From: Guy Rochez [REDACTED]
Sent: 24 March 2021 09:29
To: Nicola Moore
Cc: andrew bridges
Subject: Re: Request for further information FG/46/21/PL
Attachments: 028_Location Plan.pdf; 028_Site Photos.pdf; 028_Block Plan Proposed.pdf; 028_Plans Existing Proposed.pdf

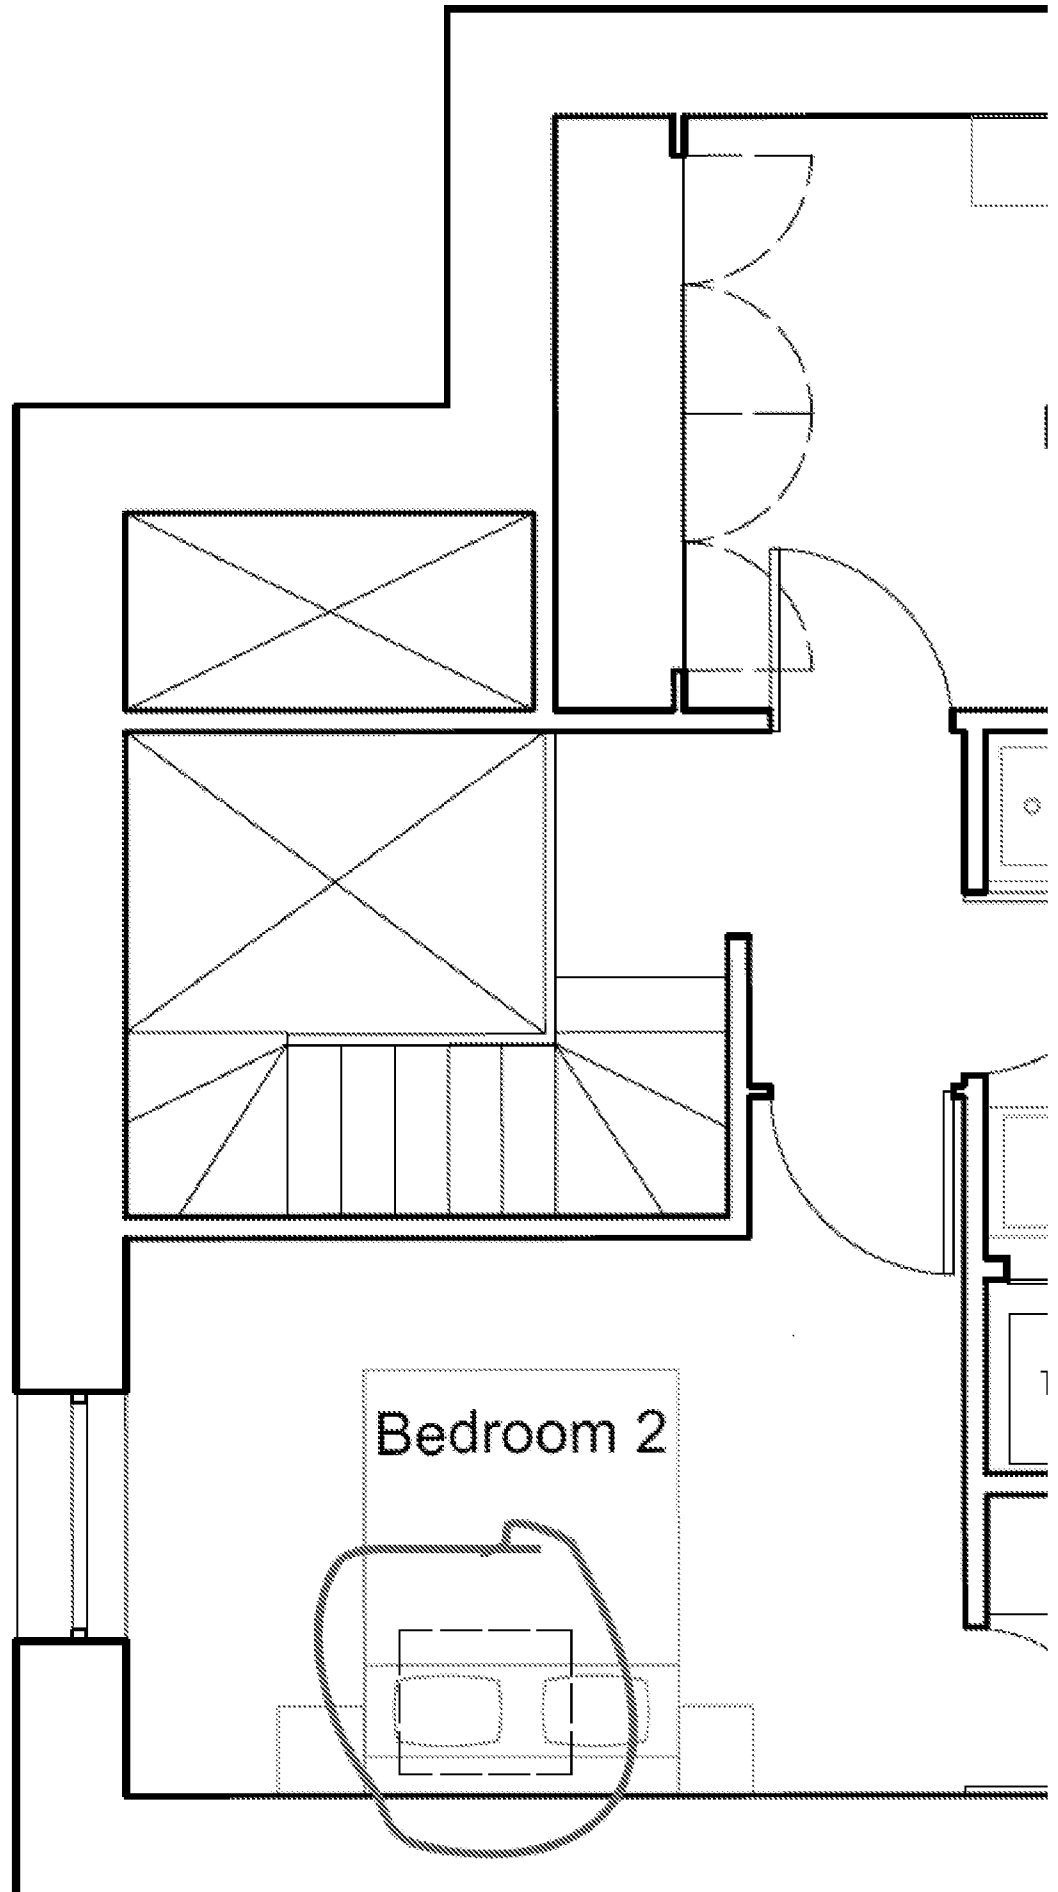
With reference to your email below, please can you amend the Location Plan to include the existing access, as per application form or if a new access is required, please include this.

- Location plan - now including arrows indicating access is currently directly available from The Grove. I also attach a pdf of site photos to demonstrate this. As I noted previously the proposal will be built from within the site itself.
- Block plan - now including measurements to the boundary
- Roof plan - now identifying the proposed roof lights (incorporated into updated 'Plans Existing Proposed' pdf)
- I confirm acceptance of the amended site address.
